Stephen O'Donoghue - FW: Re Query Mine Resources Sterilised PAC recommendation Rev 2

Please find the CHC response to your queries on the Revised Mine Plan Report.

**Percentage Woodland
Mining Area A & C**

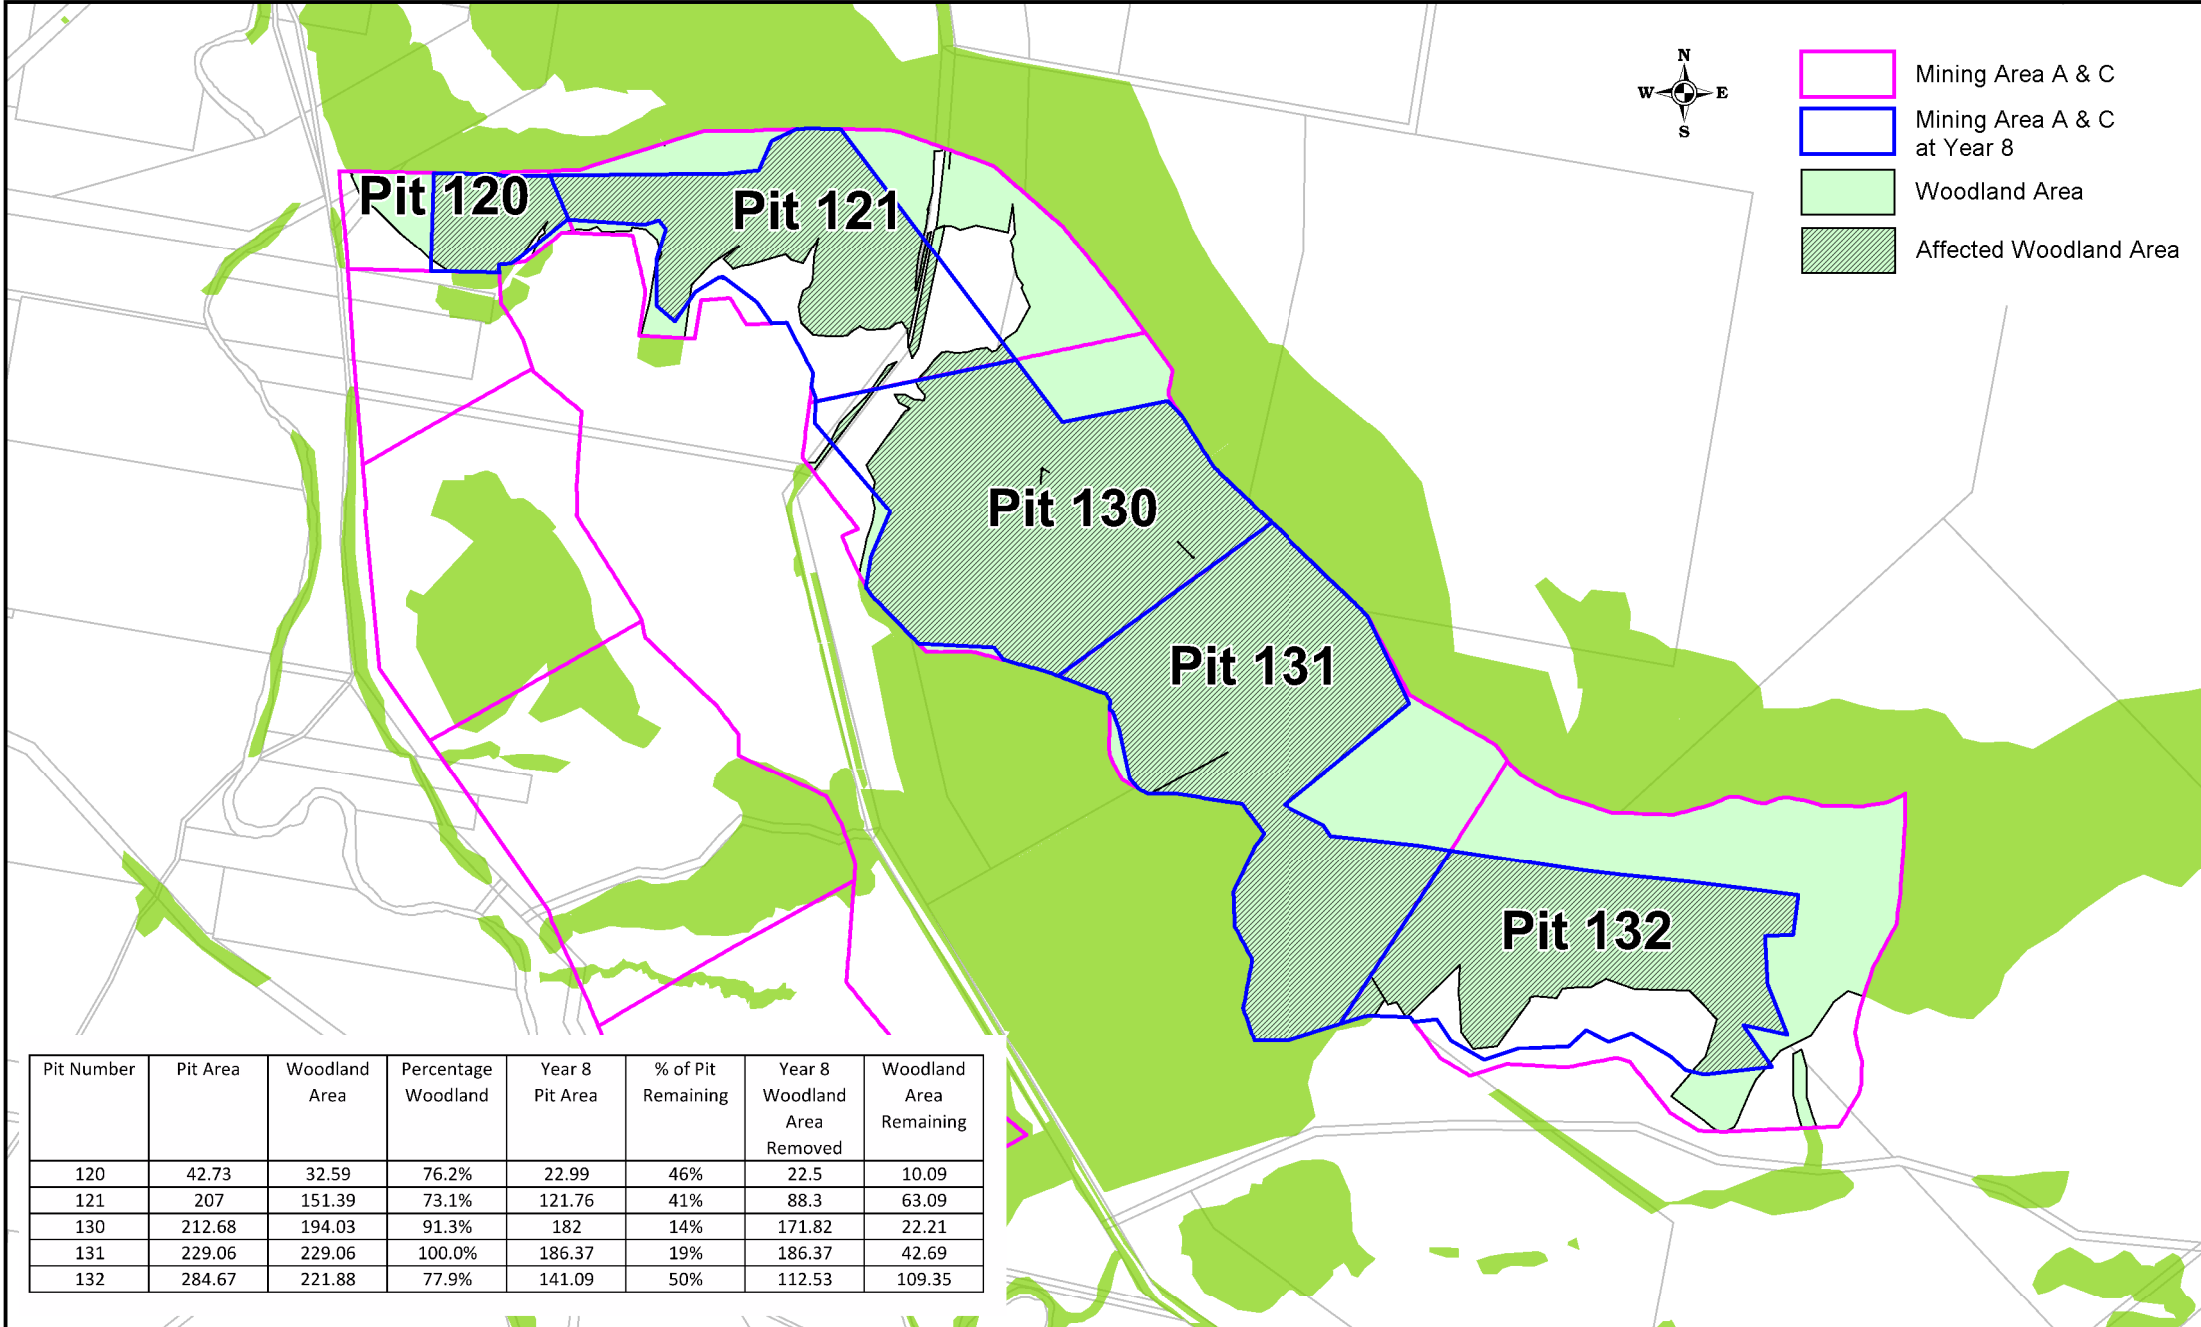
The PAC recommendation also referenced year 8 mine plan as restriction for impact on the woodland corridor. Based on a comparison of % of pit shells within year 8 disturbance footprint, by my rough calculations beyond year approximately 85MT would be sterilised - see table below. Note - I had previously requested that the coal resource lost be estimated based on year 8 disturbance. Can you get CHC to provide a better calculation on this.

With the revised plan the extent of mining in year 8 is dramatically different from that proposed in the PPR&RTS. As such CHC have generate the three figures to highlight the wooded areas within these pits:

Figure 1 % of wooded land within the pit based on the revised mine plan ie Option C of Table 5.1.

Based on the Figure 3, the sterilisation calculation is:

Pit	ROM Coal (Mt)	% Area Remaining after Year 8 PPR&RTS	Approx. ROM Coal Sterilised (Mt)	Approx. ROM Coal Mined (Mt)
Pit 120	8.7	100%	8.7	-
Pit 121	30.8	99%	30.6	0.2
Pit 130	28.2	25%	7.0	21.2
Pit 131	28.6	27%	7.8	20.8
Pit 132	35.0	90%	31.4	3.6
Option A Total	131.5		85.6	45.7
